Lane Cove Council

5 April 2019
Our Ref SU7340
Your Ref: SDD8699

Redevelopment of Greenwich Hospital (Concept Proposal) at 97-115 River Road Greenwich (SSD8699)

C CROSS SECTION - SENIORS LIVING APARTMENTS
1:250

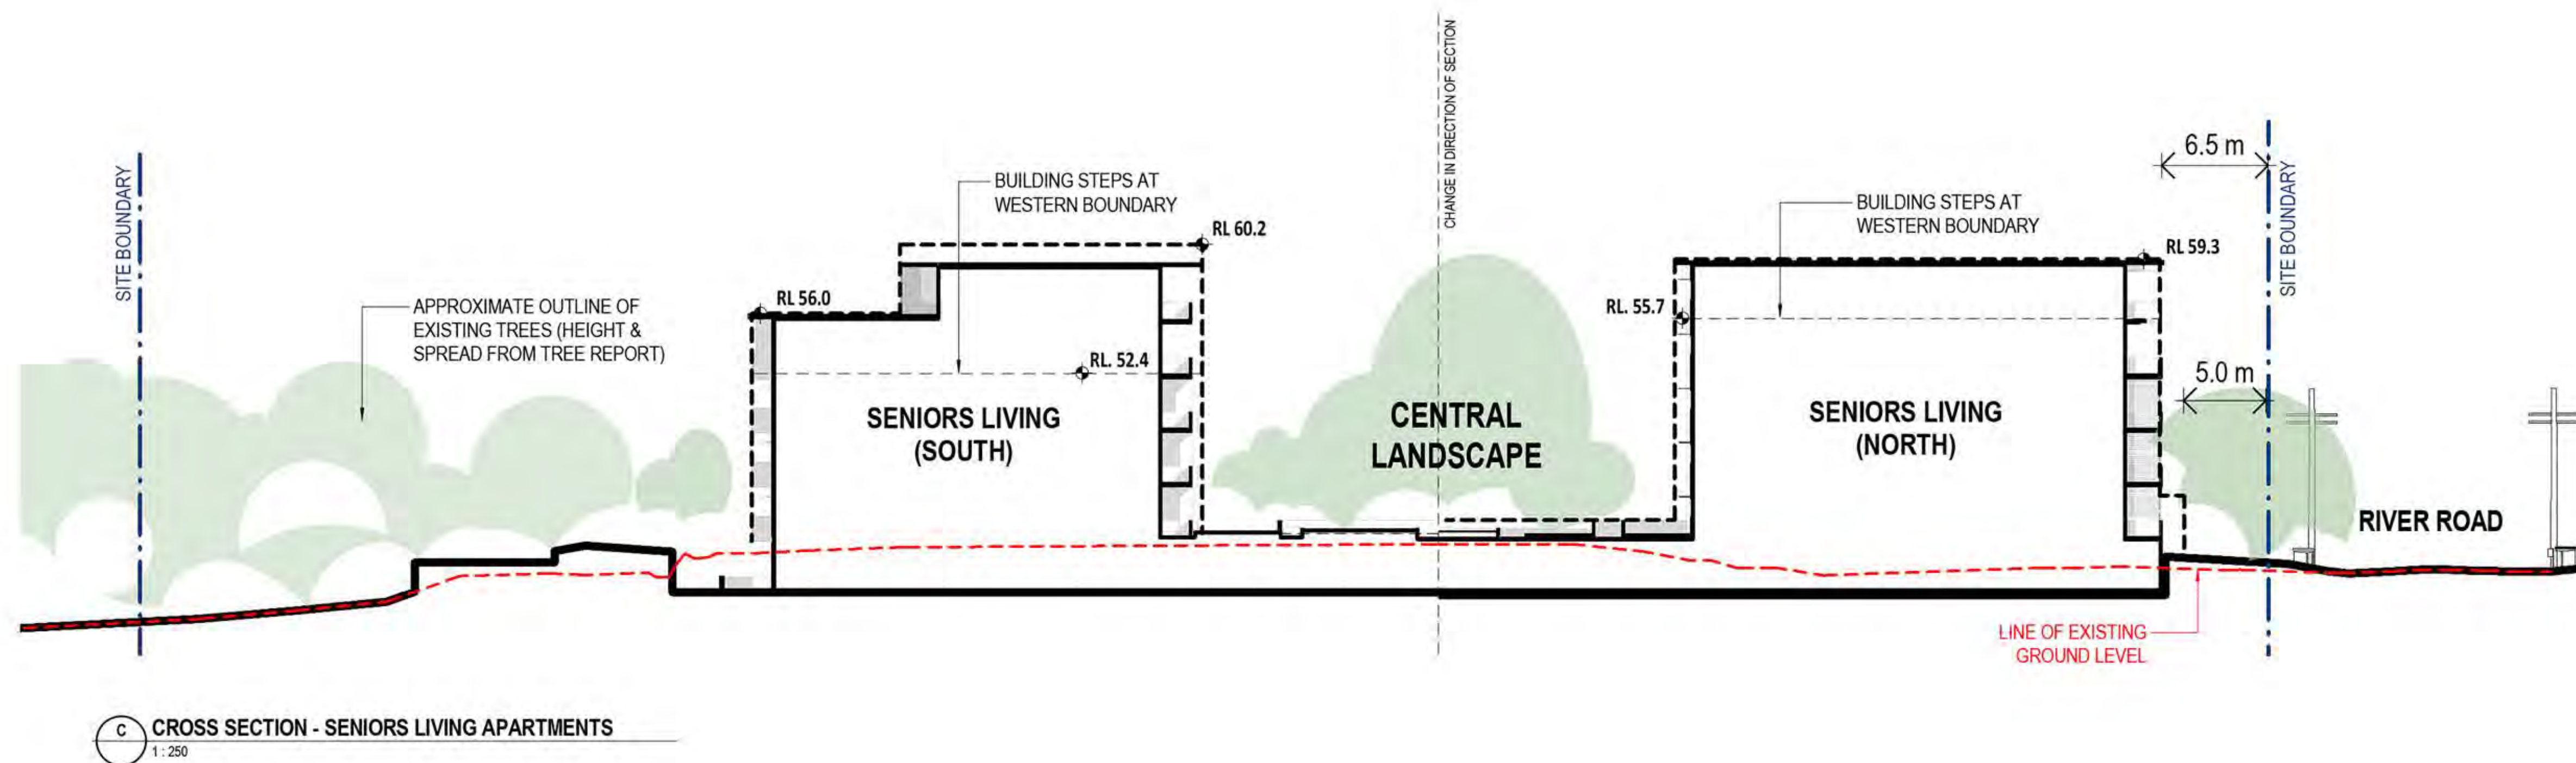
The proposed Seniors housing (apartments) would be 6-storeys and not in keeping with the scale and the adjacent development.

The bulk and massing of Seniors Living apartments would be highly visible from the public way. The existing main hospital building is setback approximately 55m from the River Road frontage. It is set behind a leafy tree lined setting and is not highly visible. The proposed 6 storey Seniors living apartments will be setback only 5m – 10m from the River Road frontage. They would visually dominate the northwest corner of the site.

DRAWING TITLE: EXISTING TREES		DATE: AUGUST 2019		DRAWN: EC		PROJ ARCH: BF		SCALE: 1: 500 @ A1	
				PROJ: 1213		DRAWING: S.10		REVISION: P5

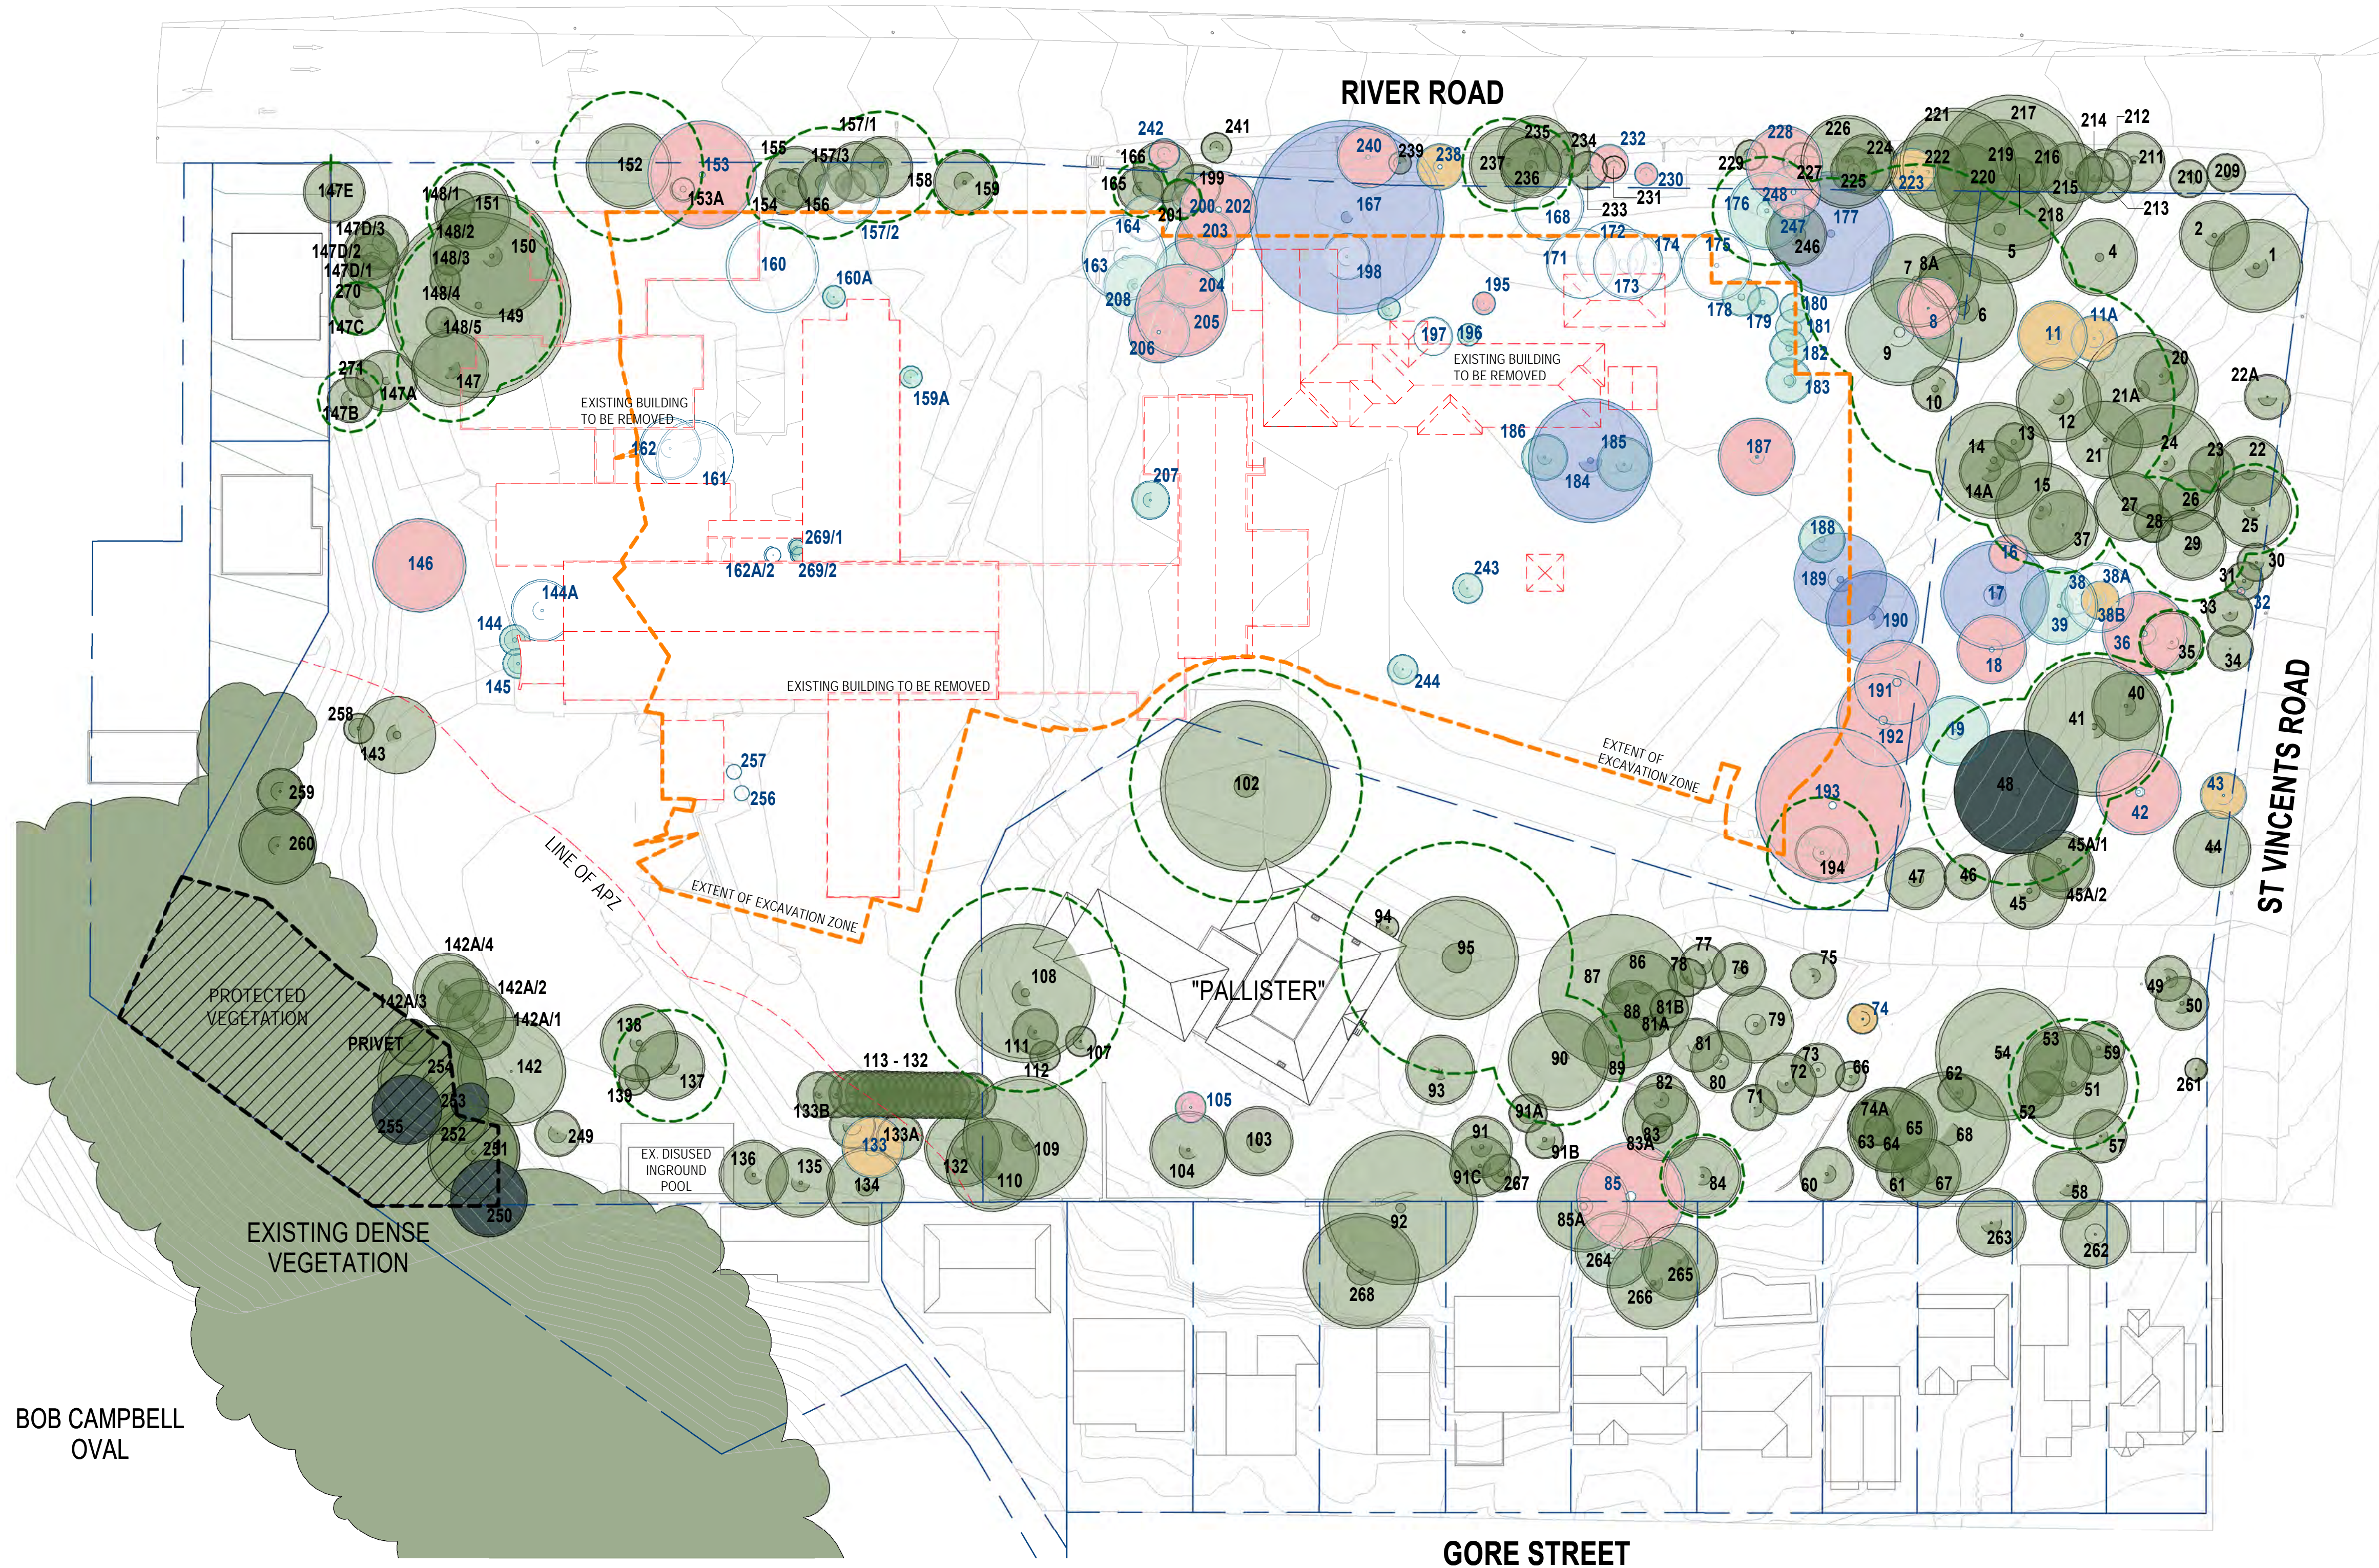
The proposed development would remove more than 50% of total tree canopy and is contrary to the North District Plan. The removal of 131 trees does not comply with the regional directives of the Greater Sydney Commission.

There are 235 individual trees located on and adjoining the site. A total of 131 of these have been proposed to be removed to facilitate the proposal, the remaining 104 have been proposed to be retained and protected for the life of the development.

A significant number of those remnant indigenous trees within the eastern part of the site along St Vincents Road are to be removed. In this area, only 2 Red Mahogany trees are to be retained, only 4 Blackbutts and only 8 or 9 Sydney Red Gum trees (as there are inconsistent recommendations for tree 79). Among the trees to be removed, a number of trees identified in this report as high priority trees for retention (trees 64, 77 176, 184).

The report does not contain scaled site plans that identify the radius of Tree Protection Zones (TPZ) or Structural Root Zones (SRZ) in relation to the proposed development.

Given the volume of trees assessed in this report it is considered scaled site plans that overlay tree data (TPZ, SRZ and canopy spread) onto the proposed plans are essential in the accurate assessment of the development.
